**CITY OF PORTLAND, MAINE
DEVELOPMENT REVIEW APPLICATION
PLANNING DEPARTMENT PROCESSING FORM
Planning Copy**

Unifirst Expansion
Project Name/Description

RE: Unifirst Expansion, 430 Riverside Industrial Parkway, Portland
Application ID No. 2006-0151
CBL: Chart 354, Block B, Lot 2

Drawing No.
C100

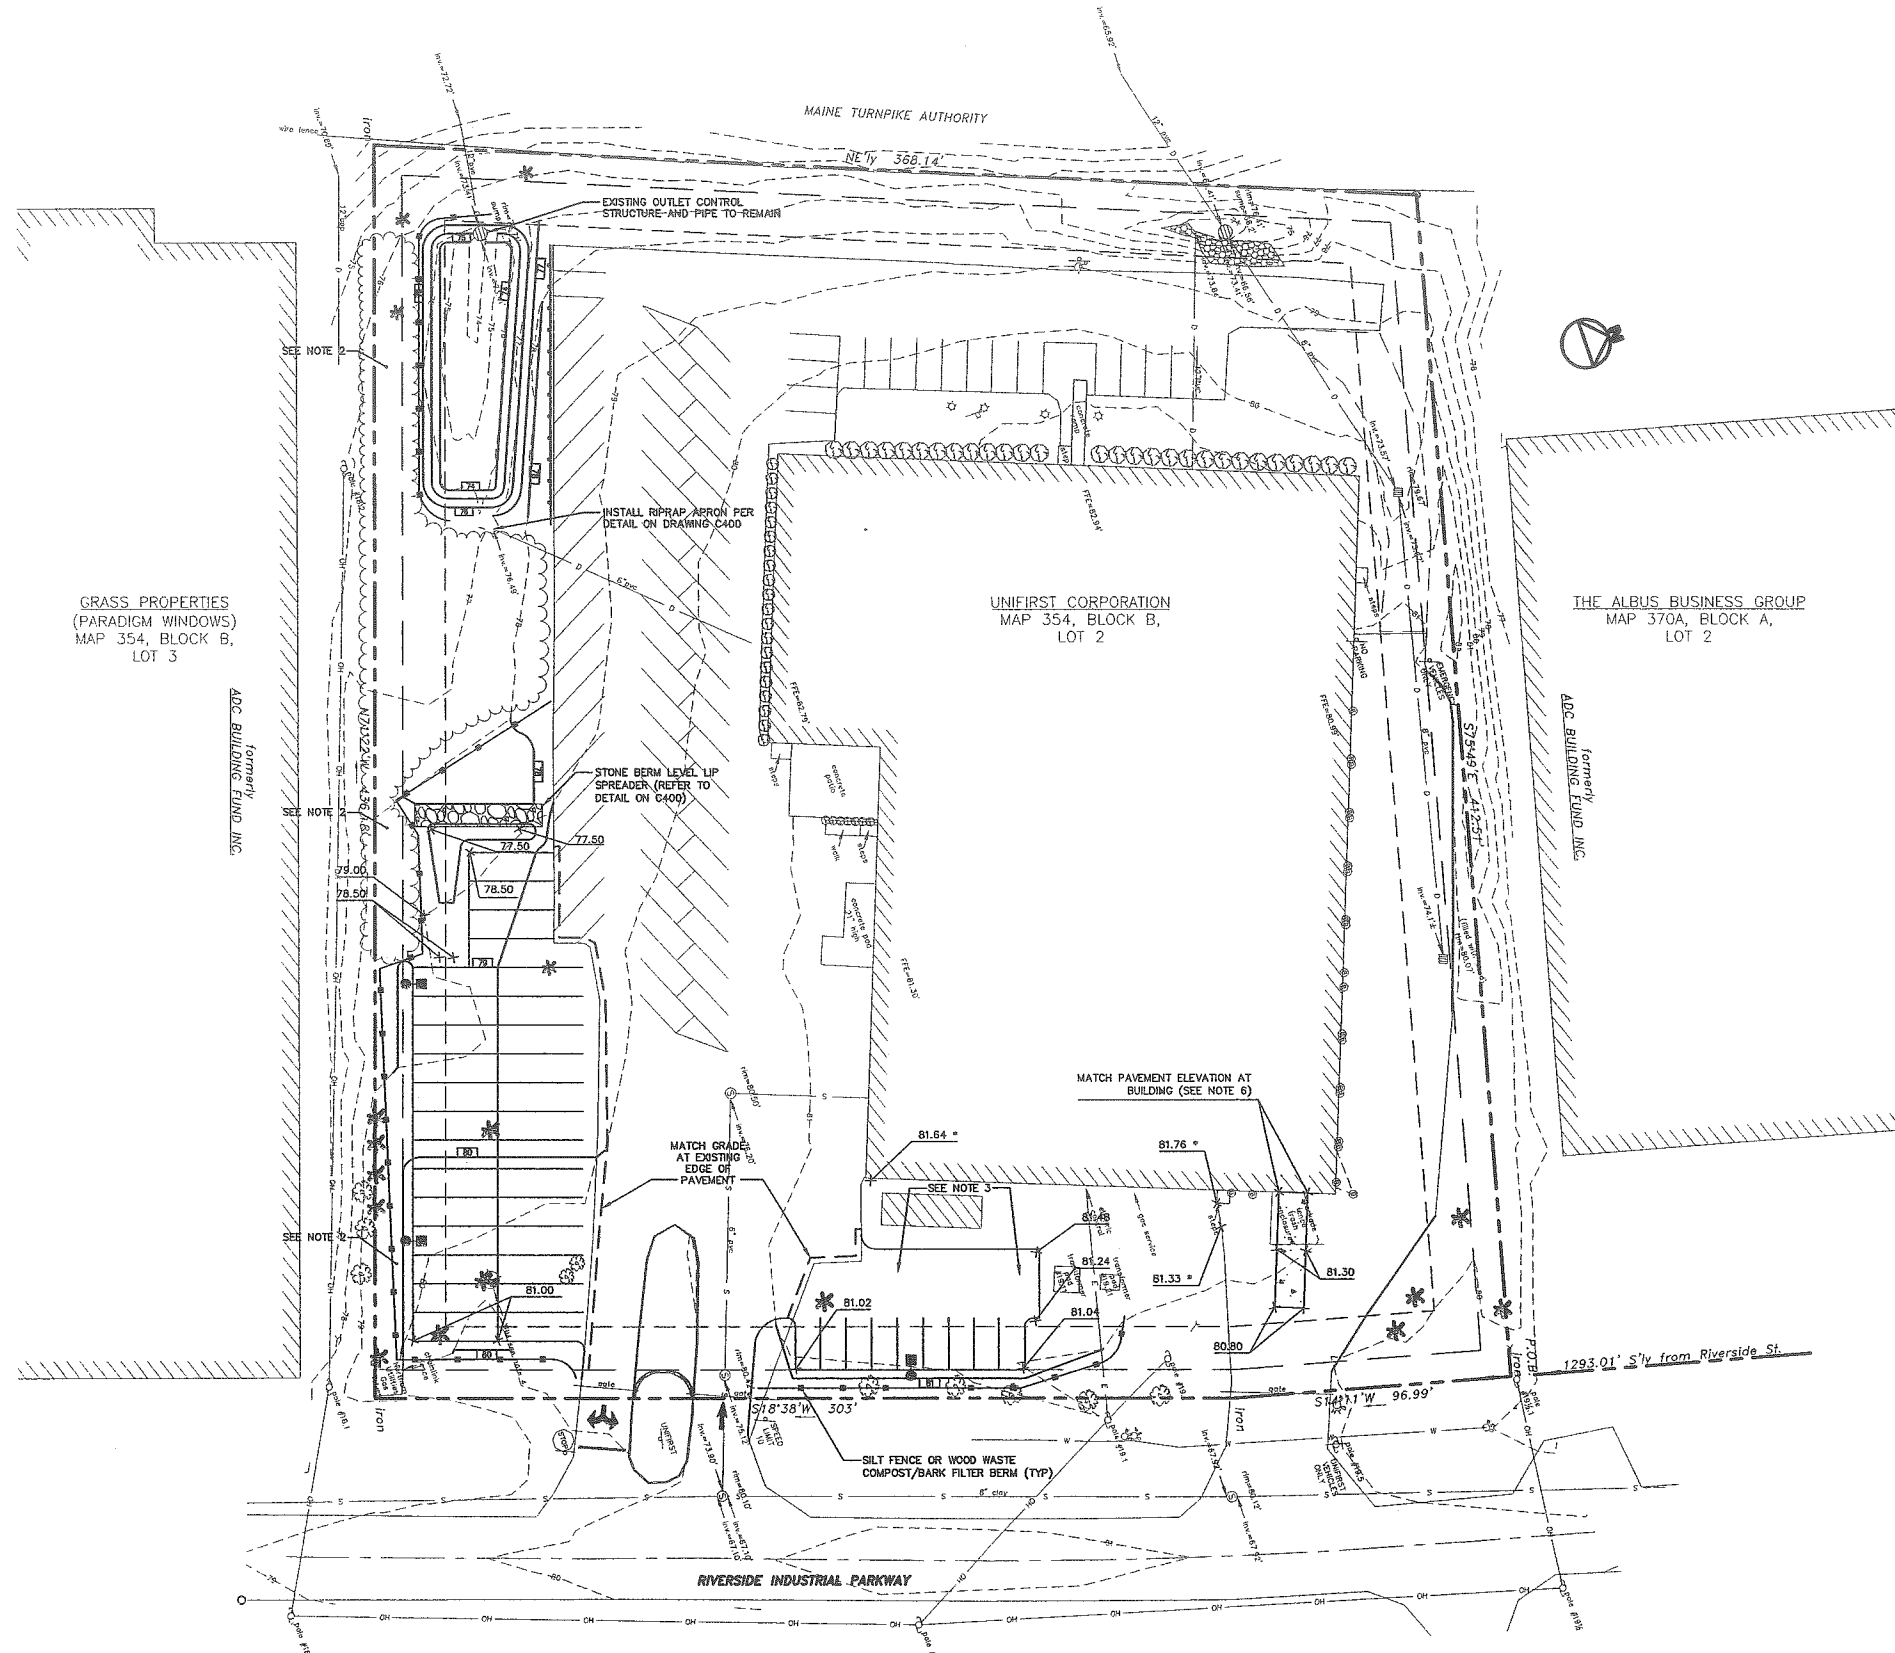
- i. That the applicant submit a revised Landscape Plan which shows adequate screening of the trash compactor and indicates all significant trees to remain and the treesave area along the south boundary, for review and approval by the City Arborist.

Remember the proposed compactor screen fence? We originally proposed a 10' high vinyl fence. Due to difficulties in getting that fence in anything but an 8' high version, Unifirst is proposing to use an alternate wood, stockade type fence. Is this acceptable?

10' high fence is needed to screen the compactor which is about 9' high.

Just touching base on a few things for UniFirst. Drawing C100 indicates a 10' high stockade fence at the dumpster pad. Would there be a problem changing this to an 8' high fence? Fence contractors seem to stock 8' in lieu of 10'.

I confirm that the City Planning Division has approved the proposed fencing and gate details as shown in the the two attached sketches and also confirm that the Condition i of the Approval letter dated October 24, 2006 has been complied with.

Just to confirm that we are happy in principle with this proposal but would like a sketch of the gate for the record.
